# **THE STAR MODIFICATION 14 (MP 08\_0098)**

## **HERITAGE RESPONSE TO COMMENTS**

Urbis has been engaged by The Star Entertainment Group to prepare the following response to the comments pertinent to Modification 14 (MP 08\_0098 MOD14) which involves various additions and alterations to The Star Casino. This report is primarily concerned with works which have the potential to visually or physically impact on The SELS building which is located in the northern west corner of The Star.

Architect
dwp[suters
www.dwpsuters.com
Project
THE STAR - MODIFICATION 14
Location
80 PYRMONT STREET
PYRMONT NSW 2009
Client
THE STAR ENTERTAINMENT GROUP
Drawing
SELS BUILDING SCOPE OF WORKS
Scale
1:100 @ A1
Date Printed
2/17/2017 10:38:24 AM
Project Number
303457
Drawing Number
MOD14-A3000
Issue
B

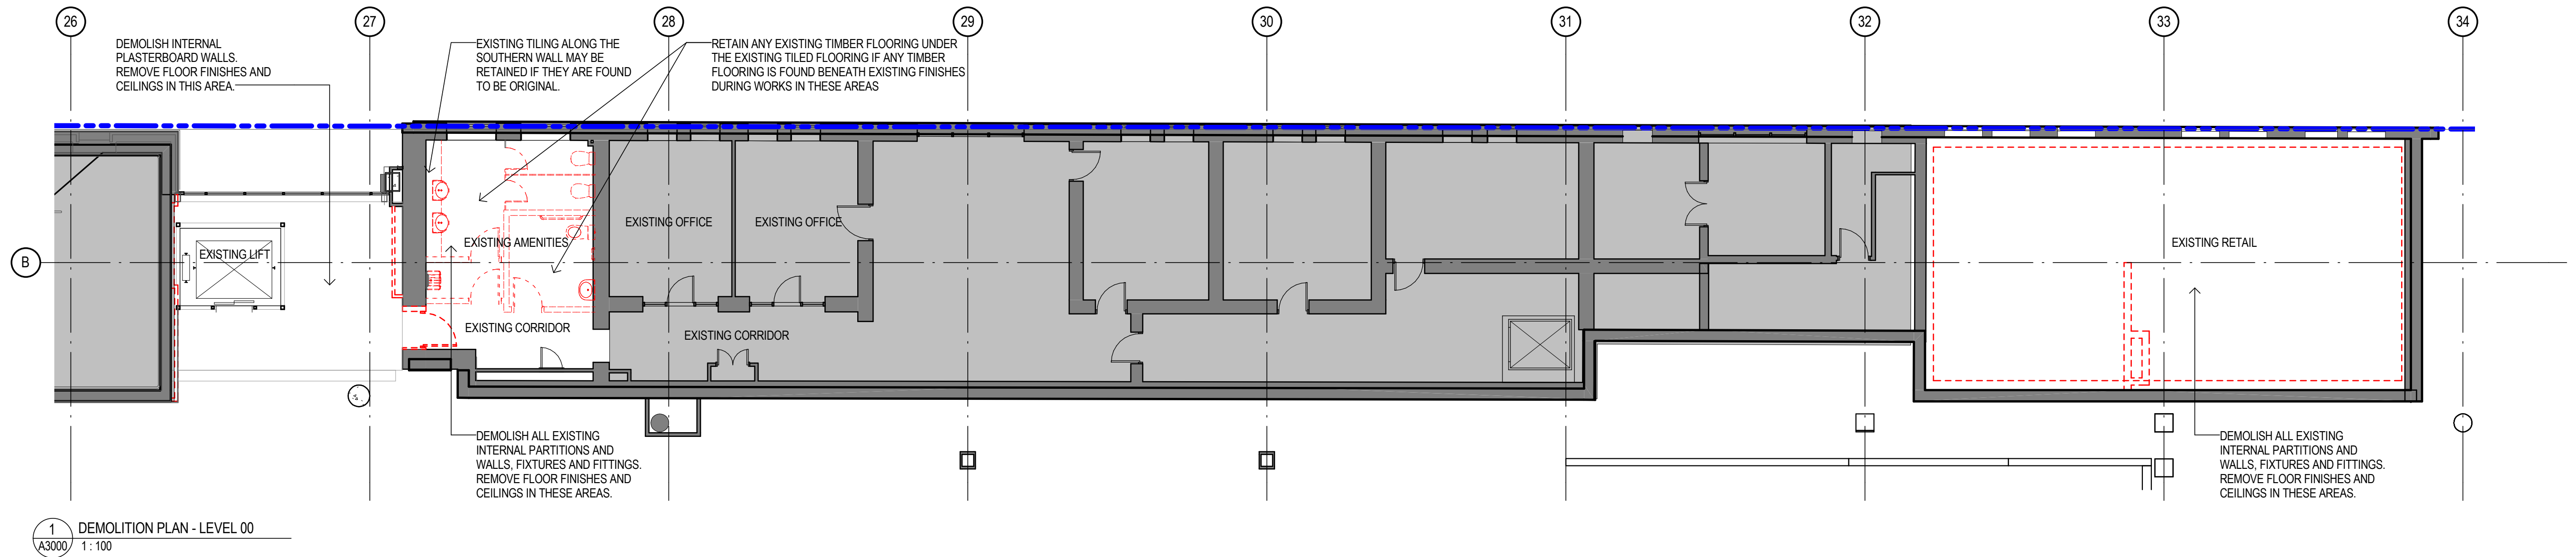
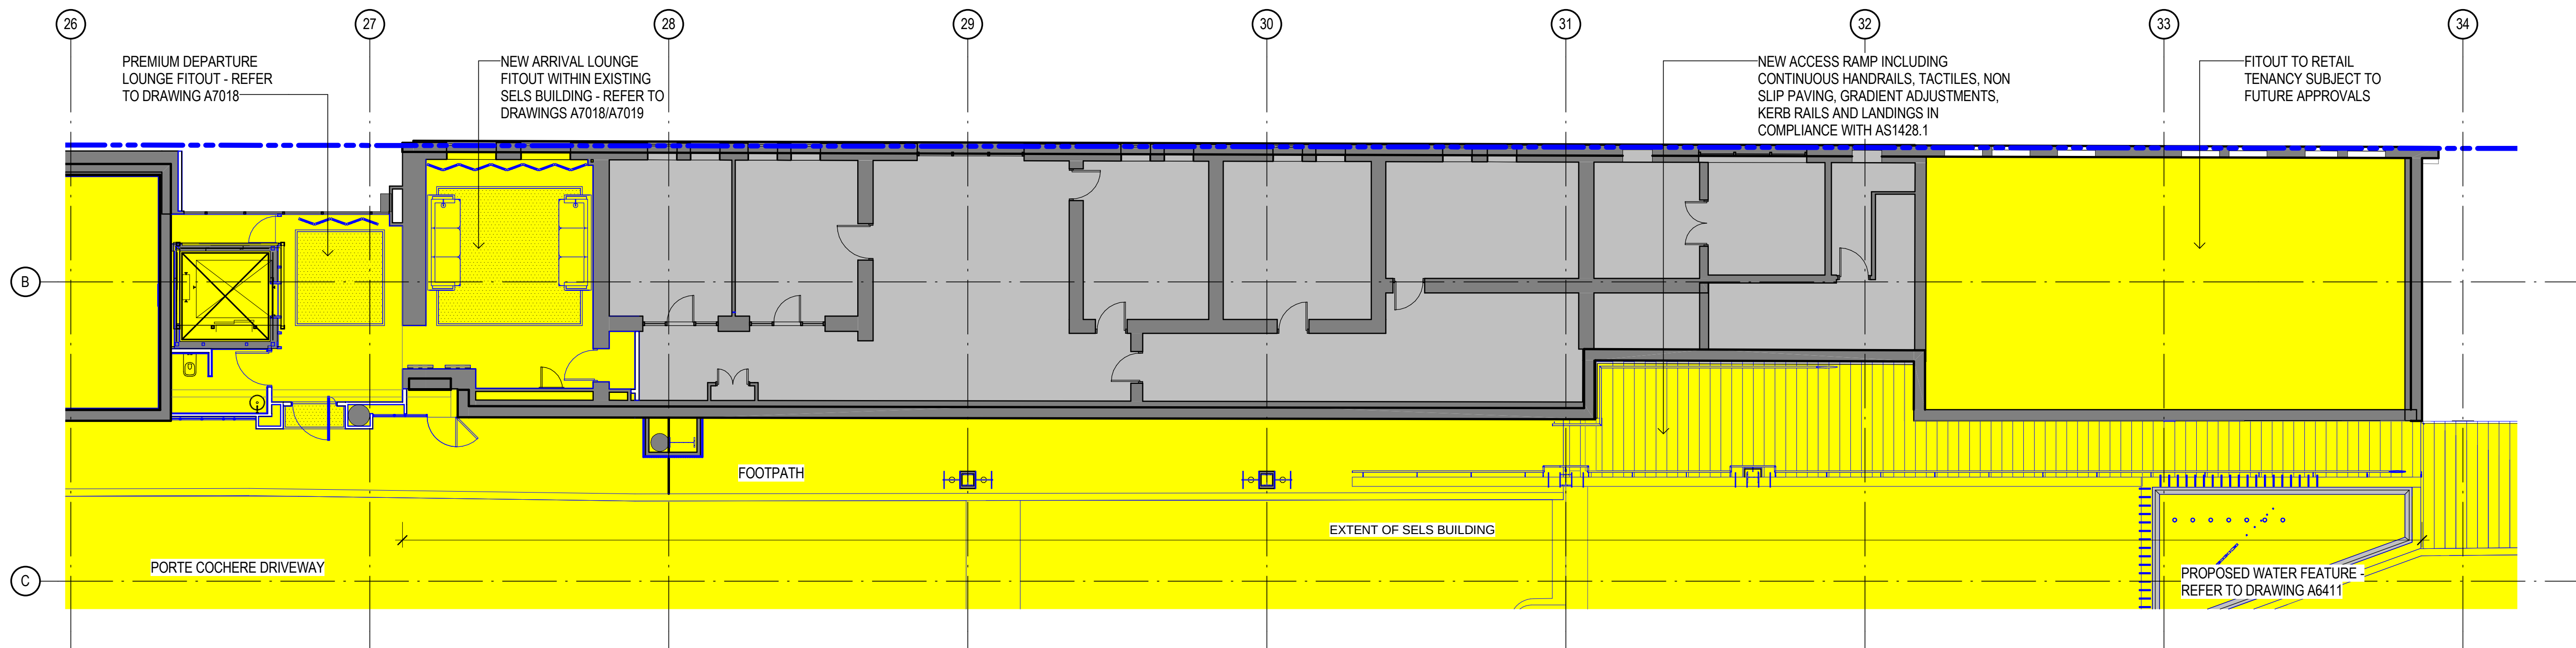
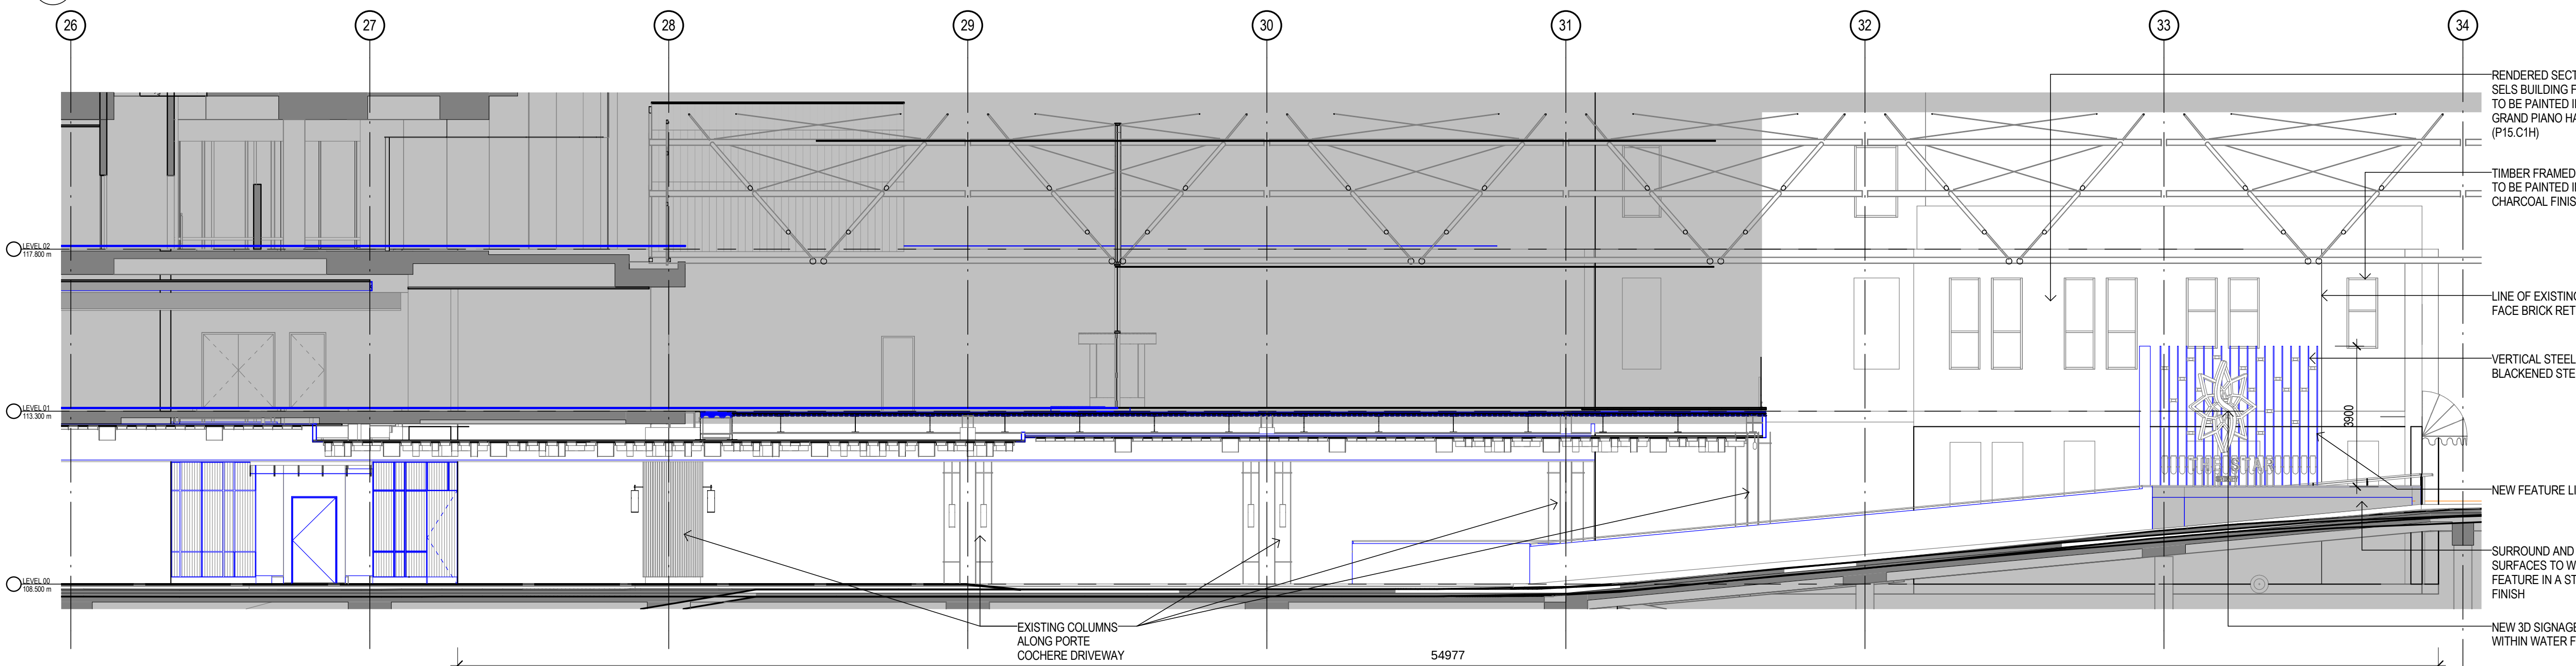
- *The level of detail in the MOD 14 drawings is inadequate to determine what is being proposed and to assess the impact of the works. The proposed works to The SELS building should be shown clearly on drawings, at least at a scale of 1:100 at A3.*

**(Refer Section 3.1 below for discussion).**
- *Fitout to the retail tenancy in the SELS Building is subject to “future detail” and should be the subject of a separate DA.*

**(Refer Section 3.6 below for discussion).**
- *With regard to the arrival lounge, the demolition plan is unreadable and the proposed changes are difficult to decipher. Clear detail of the demolition and the changes being proposed should be shown on the drawings, including section, which should include the extent of demolition, lightweight construction of the new partition for the butler’s pantry and other changes to the room layout, removal of the suspended ceiling, details of screening etc.*

- *If any original timber flooring is found under the carpet in The SELS during the construction work of the Arrival Lounge, this should be retained either below the new floor finishes or incorporated into the new finishes for the space.*

- *The existing tiles on the southern façade of the ground floor bathroom should be incorporated into the finishes schedule for the Arrival Lounge or retained behind the proposed finishes.*

Drawings specific to The SELS building have been provided at a scale of 1:100@A1. Refer to the following drawings:

Any fitout to the tenancy will be the responsibility of the future tenants and will be addressed as part of a future applications. Under this application, it is proposed only to remove the existing contemporary fitout. This will have no heritage impact.

The demolition plan has been provided at a scale of 1:100@A1 and the new works have been represented in revised drawings.

In summary, the proposal requires the demolition of later fabric including partition walls and suspended ceiling. Allowance is made for the retention of any original flooring or ceilings found during the works behind the proposed finishes/ceiling.

Provision is made for the retention of any original flooring if it is found during works (refer 303457\_A3000 prepared by Suters).

Provision is made for the retention of the tiles if they are found to be original (refer 303457\_A3000 prepared by DWP Suters).

Drawing  
WATER FEATURE DETAILS

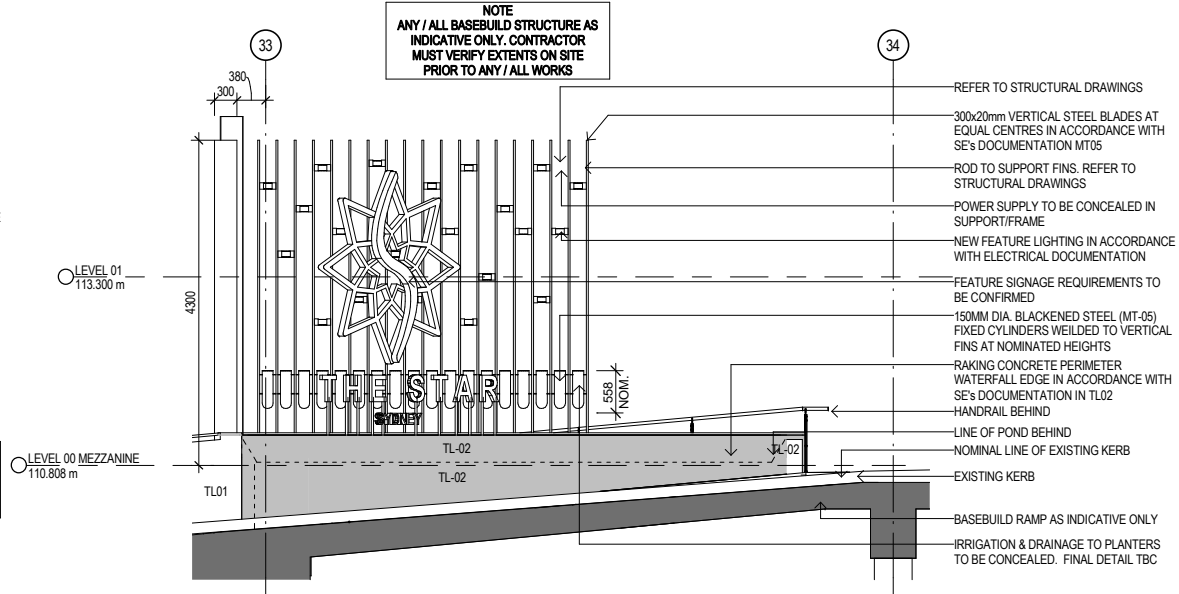
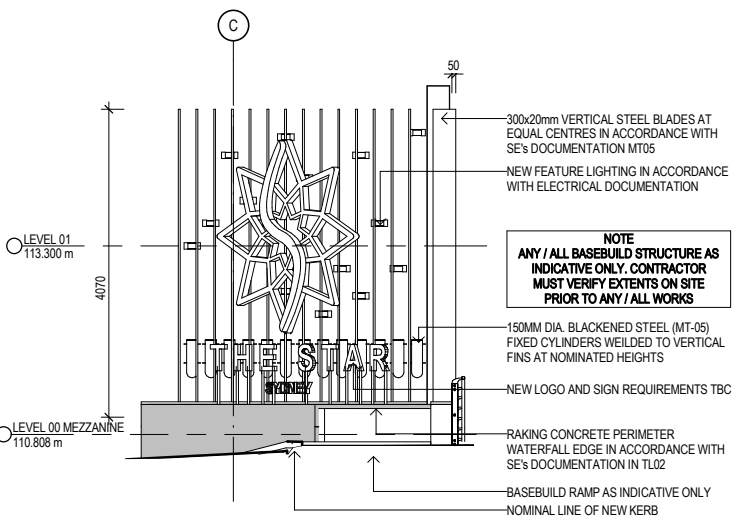
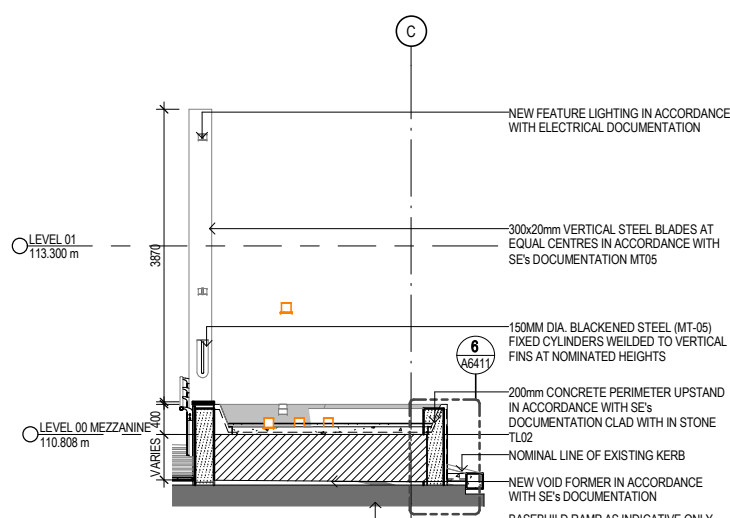
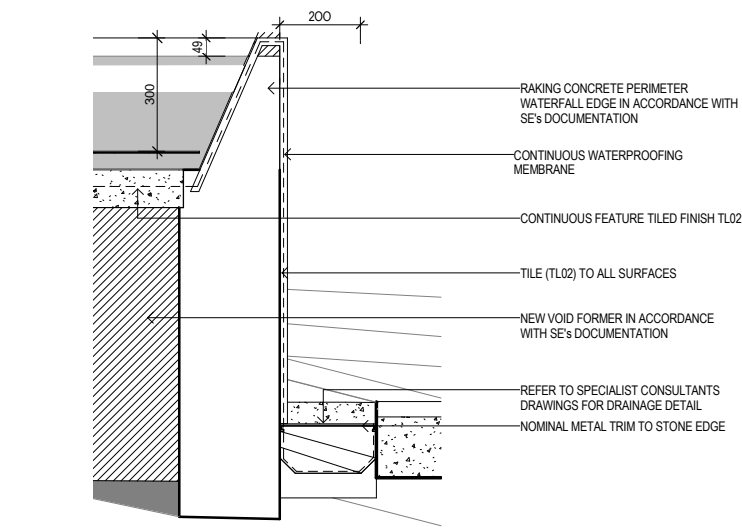
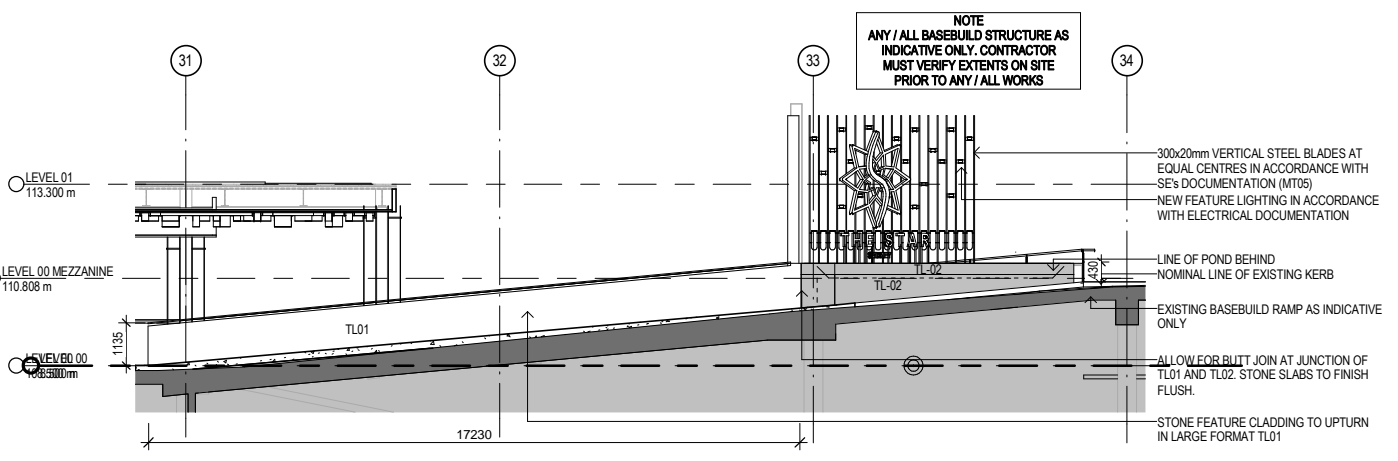
- *The design of the proposed water feature, including its form, proportions, material and colour should sit well and engage harmoniously with the architectural style of The SELS building. More information and design detail should be submitted by the applicant to enable proper assessment.*

**(Refer Section 3.7 below for discussion).**
- *In relation to the proposed water feature and sculpture on the porte cochere side of the SELS building, no details have been submitted on the drawings for this feature. In pre DA advice given by the City to The Star, the City recommended that to reduce its visual impact on the SELS building the water feature structure should be no forward of the line of the face brick return of the SELS building and be reduced in height such that the top of it is no higher than the base of the sill of the first floor double hung sash window within this brick return section of the building.*

The water feature has been designed such that it does not extend higher than the sill height of the first floor window openings on the eastern façade of The SELS. It has been sympathetically sited such that it sits minimally forward of the face brick return of the northern façade. This is in line with the Pre DA feedback received from the City of Sydney Council heritage advisor in 2016 and would mitigate the visual impact of the fountain on the primary (north) façade of The SELS.

The water feature has been designed such that it is not higher than the sill height of the first floor window openings on the eastern façade of The SELS. It has been sympathetically sited such that it sits minimally forward of the face brick return of the northern façade. This is in line with the Pre DA feedback received from the City of Sydney Council Heritage advisor in 2016 and would mitigate the visual impact of the fountain on the primary (north) facade.
